Fire Marshal Division

**Re: Dr. Ken Rhea Vet Clinic
101 S. Main St.
Lillington, NC 27546**

Application Number FMFW2010-0005

DR. KEN RHEA VET CLINIC		
SCALE: 3/16" = 1'	APPROVED BY:	DRAWN BY: Cecil Peebles
DATE: 10-16-2020		REVISED
101 S. MAIN ST. LILLINGTON, NC. 27546		
CECIL PEEBLES P.O. Box 490 Lillington, NC 27546		DRAWING NUMBER

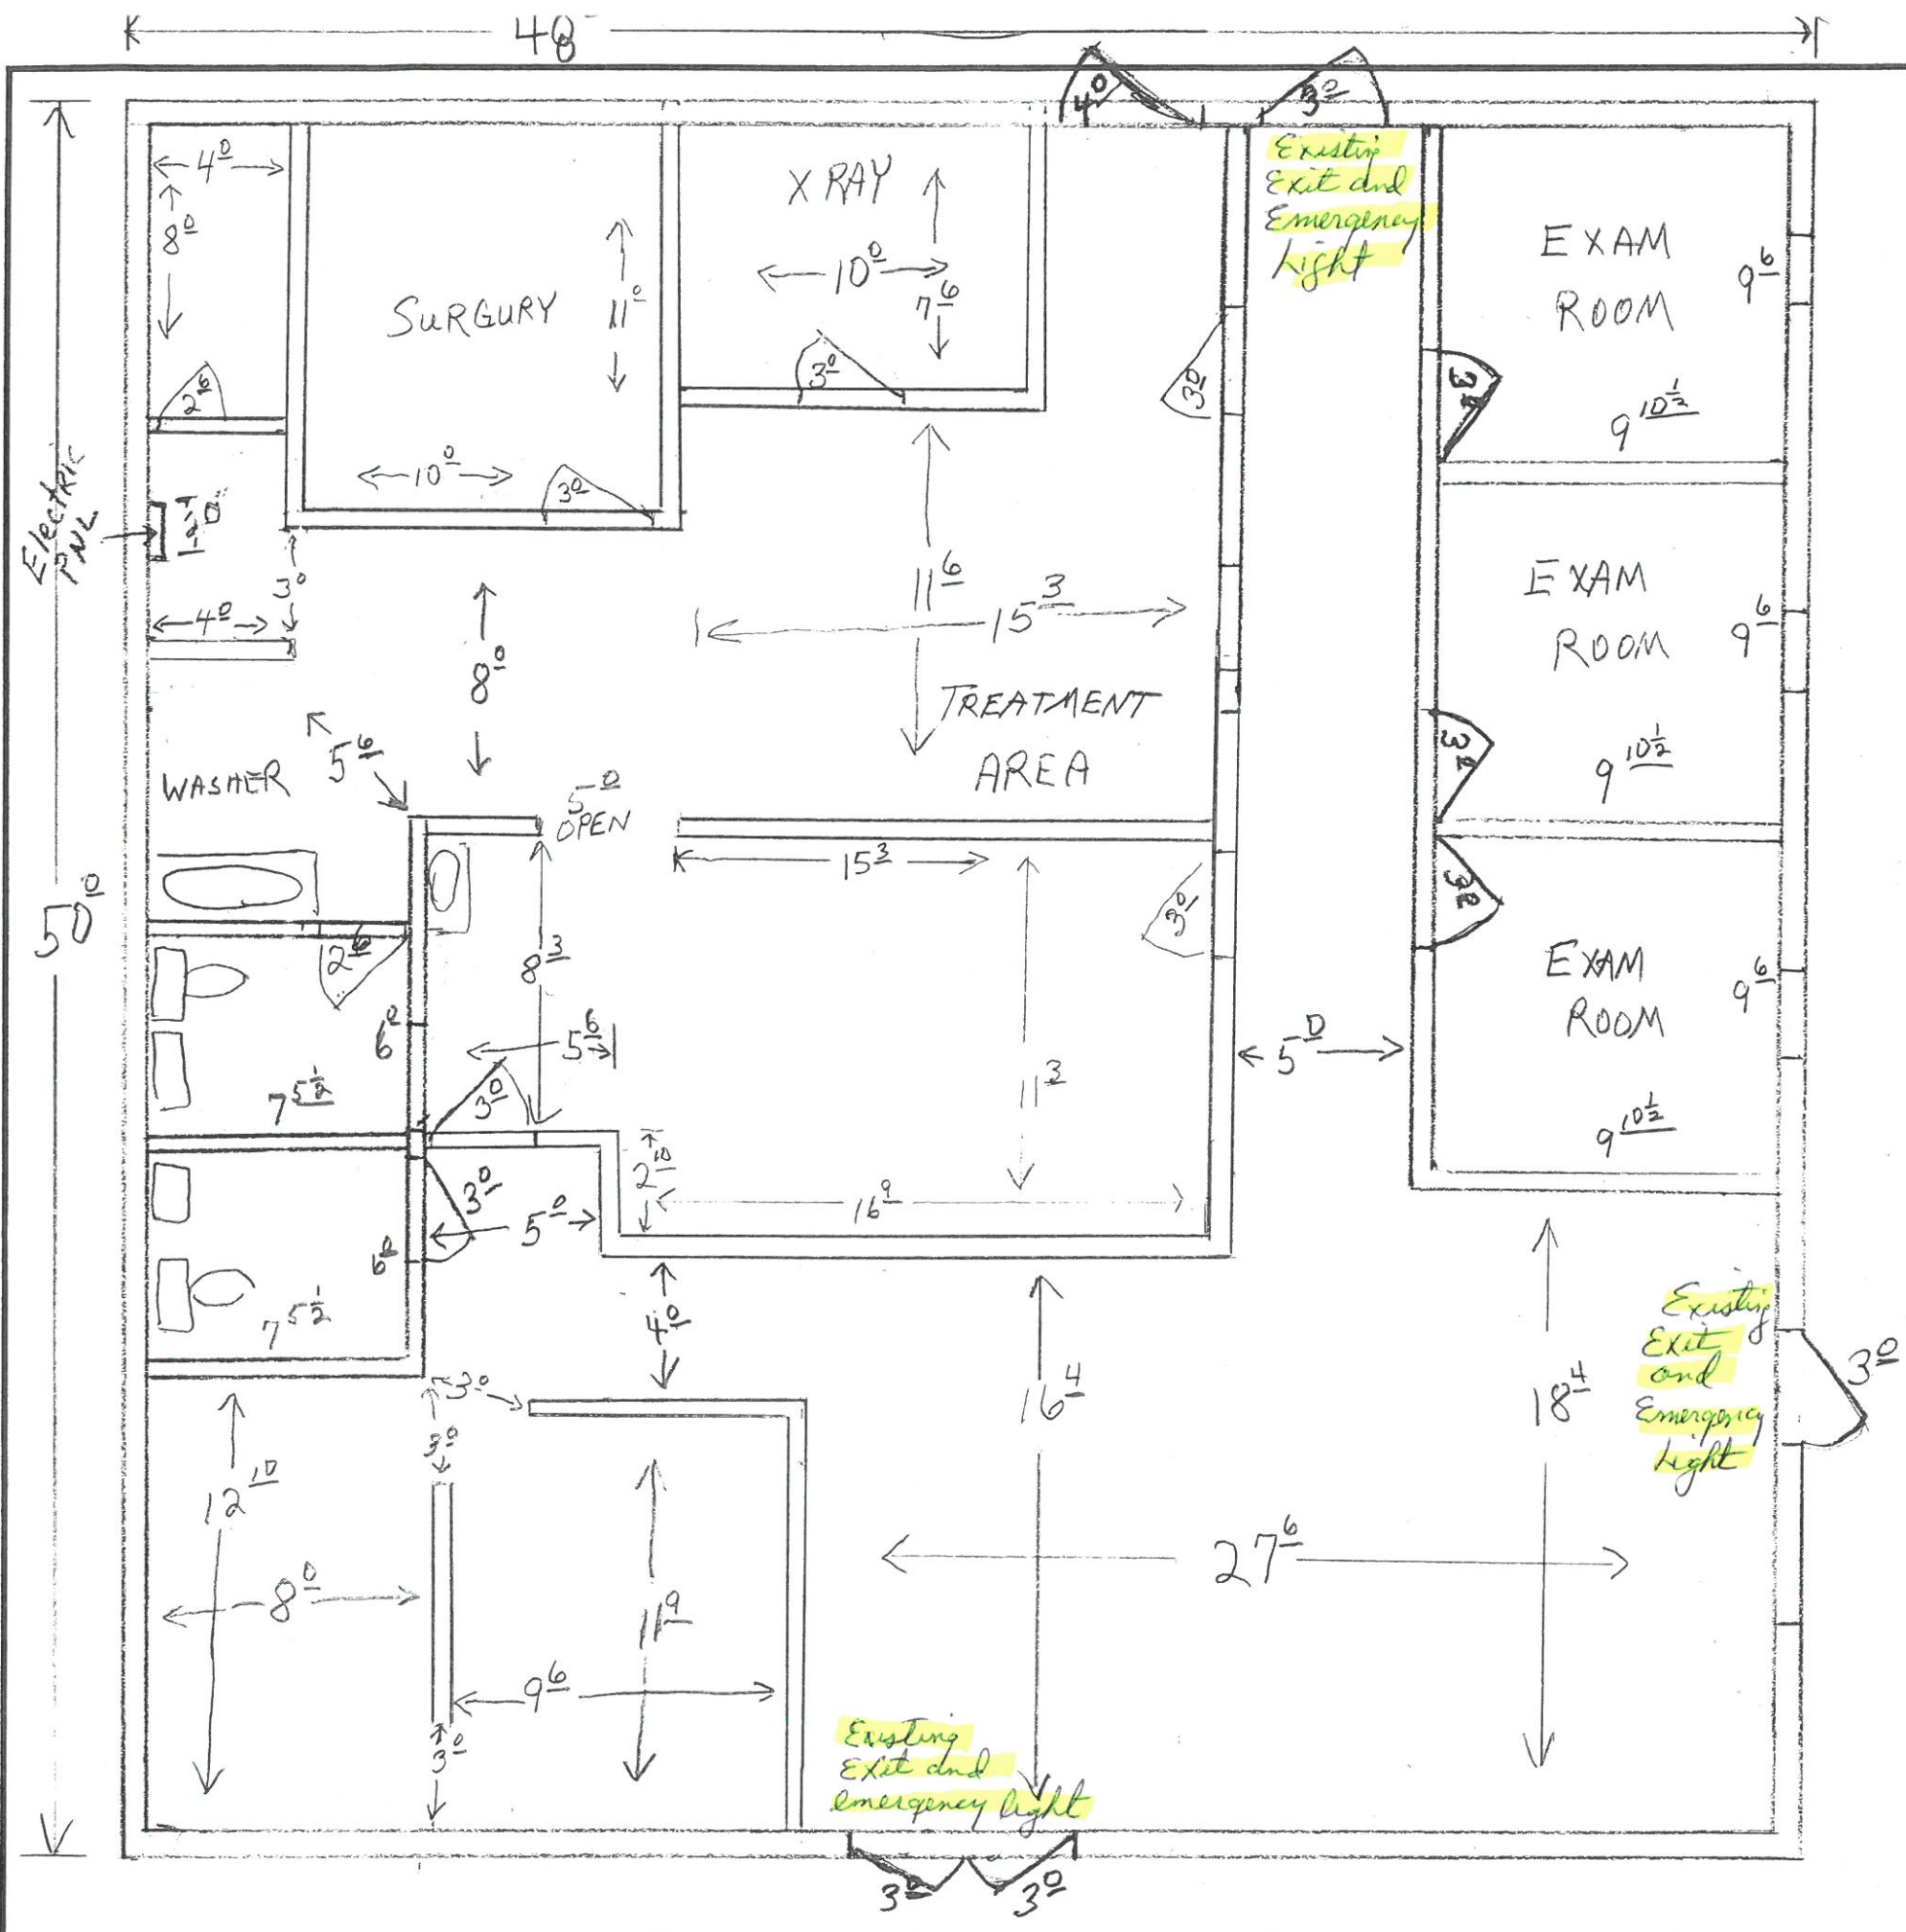
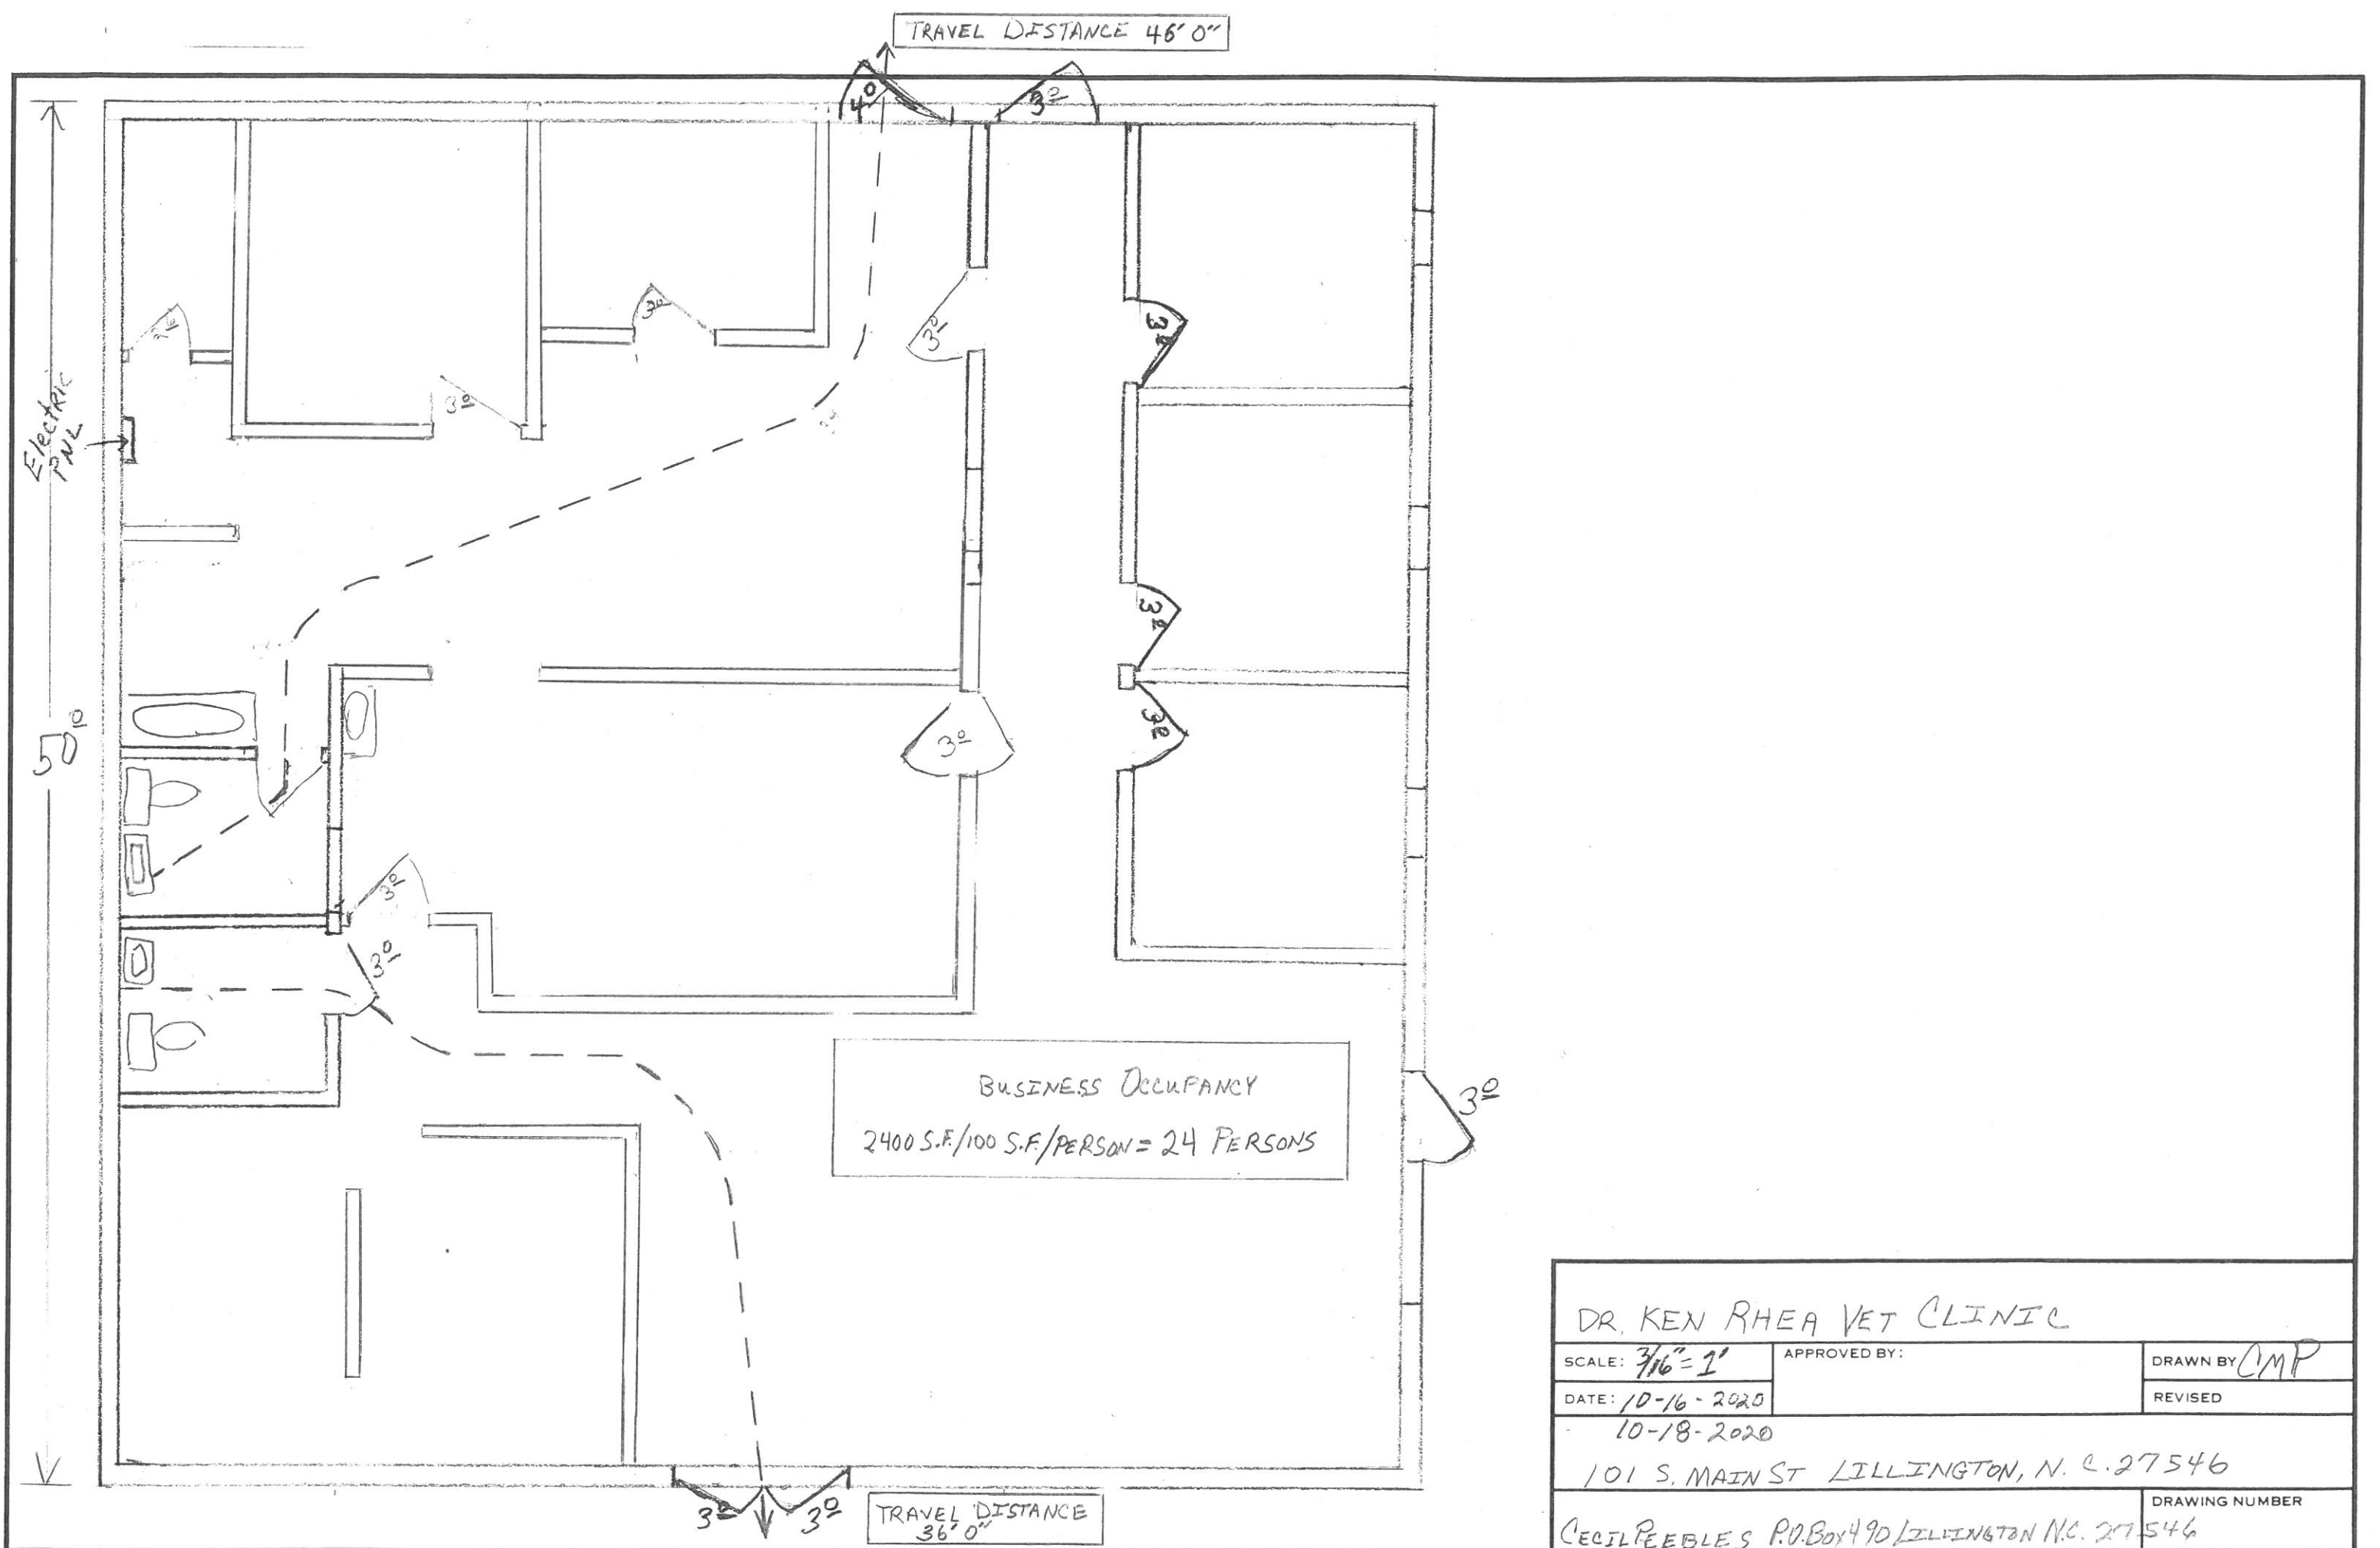
- Minimum of (1) 2A10:BC fire extinguisher shall be installed not to exceed 75' distance of travel.
- All Fire extinguishers shall be properly mounted and tagged by a fire extinguisher company.

- The means of egress, including the exit discharge, shall be illuminated at all time the building space is served by the means of egress is occupied.
 - Means of egress consist of three separate and distinct parts: the exit access, the exit and the exit discharge.
- The means of egress illumination shall not be less than 1 foot-candle at the walking surface.

- **All additions to existing systems shall properly communicate to existing fire panel.**
- **A fire alarm construction permit is required.**
- **Please schedule all inspections through the Fire Marshal's Office. 910-893-0742.**
